FW: Planning Application Consultation: NC/23/00490/DPA OFFICIAL - Public

NC.23.00490.DPA - Weldon, 1A Church Street

Proposed Site Plan
 1 : 500

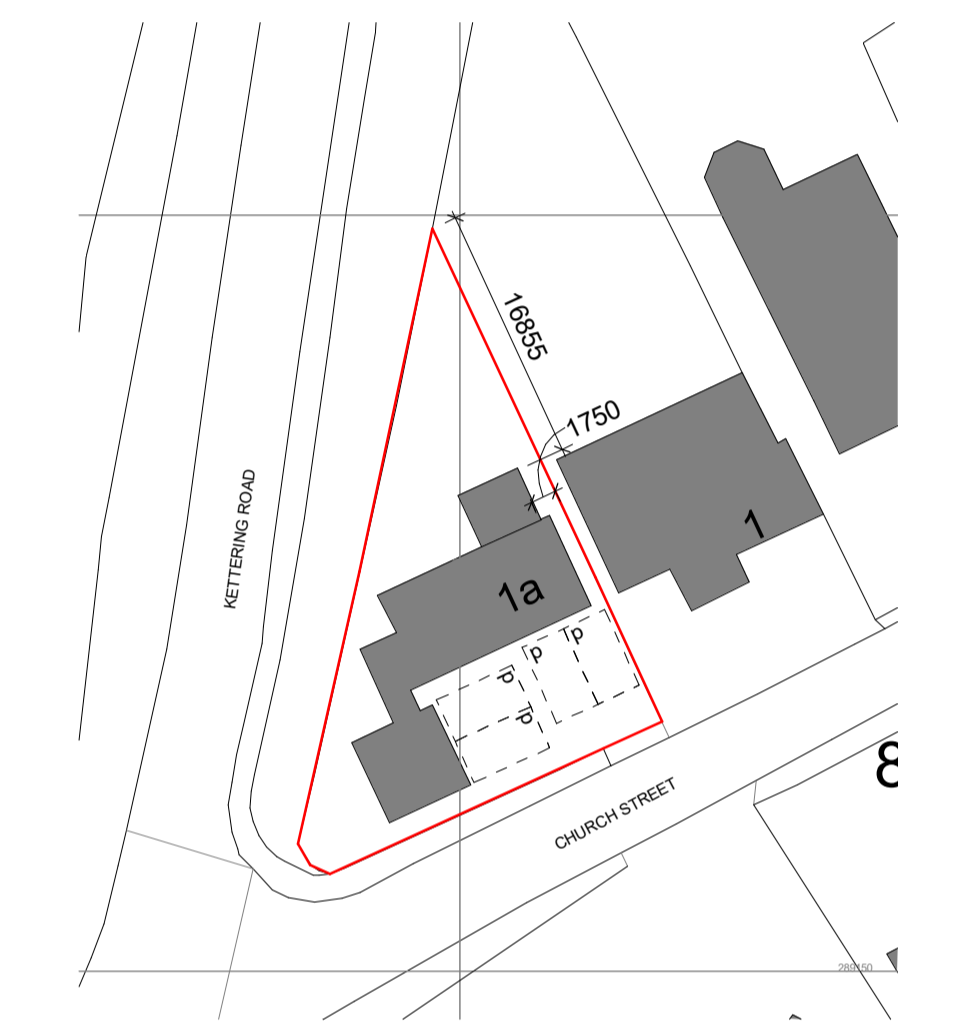
The LHA do not object in principle. Whilst the resulting single garage is substandard, there is thought to be sufficient space within the driveway to accommodate the required parking.
